Ribble Valley Borough Council
By email

Your ref 3/2025/0363
Our ref DC/25/1830
Date 11-AUG-25

Location: Land off Pendle Street East Sabden BB7 9EQ
Proposal: Erection of 19 no affordable dwelling (100% affordable housing scheme) with associated car parking

Lees Roxburgh Drg. No. 6757/01-02

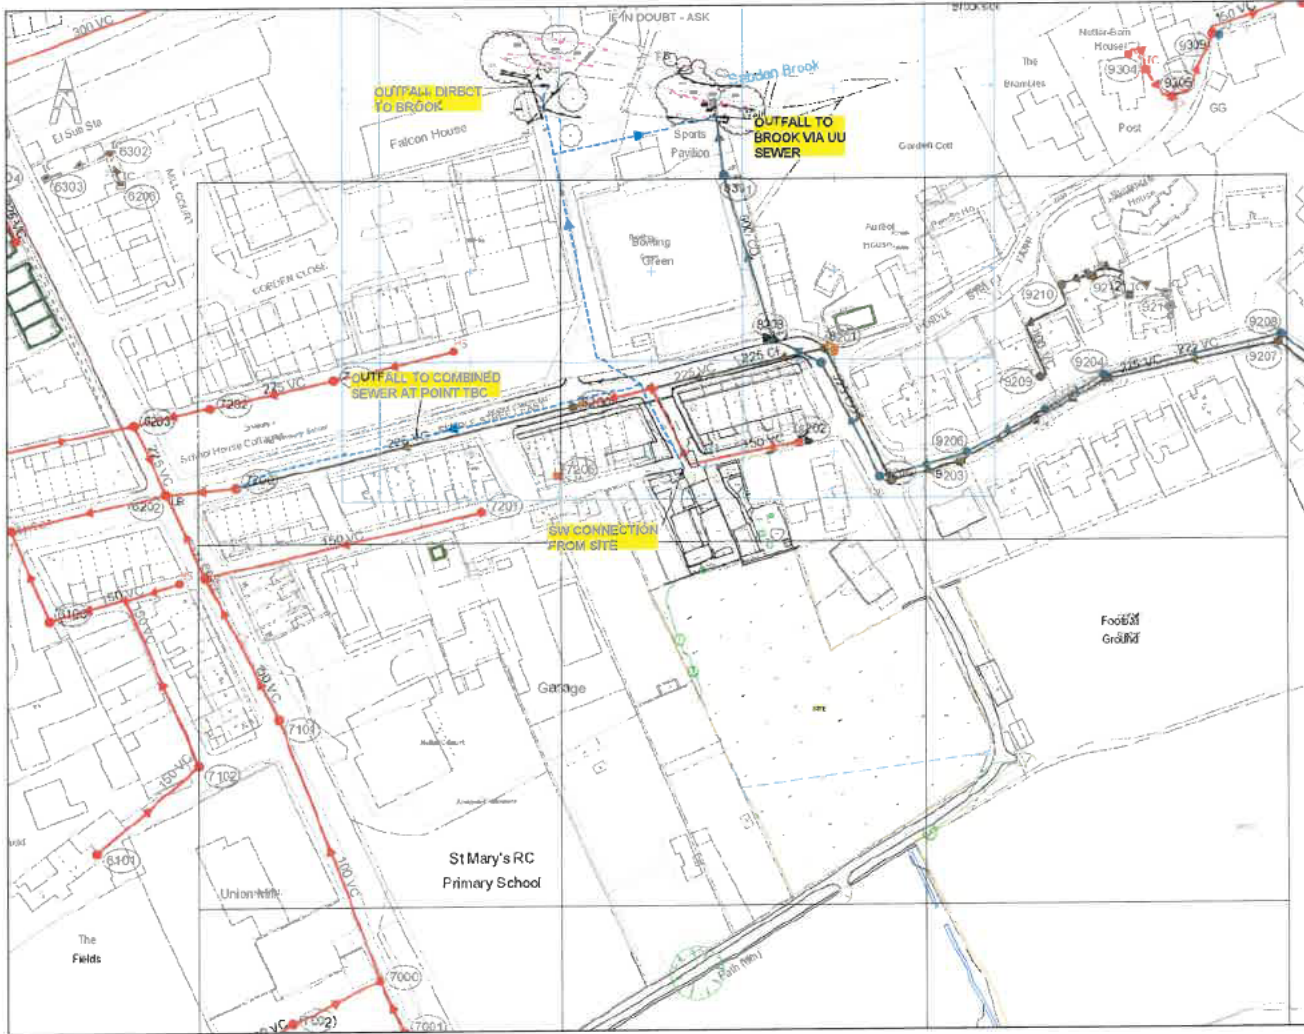
Following our review of the submitted drainage documents; Flood Risk Assessment, dated April 2025, ref: 6757/R1, the drainage proposals are not acceptable to United Utilities. This is because our record shows local watercourses cross the site and is next to the site. We have not seen robust evidence that that the drainage hierarchy has been thoroughly investigated and the proposals are not in line with the National Standards for Sustainable Drainage Systems (2025).
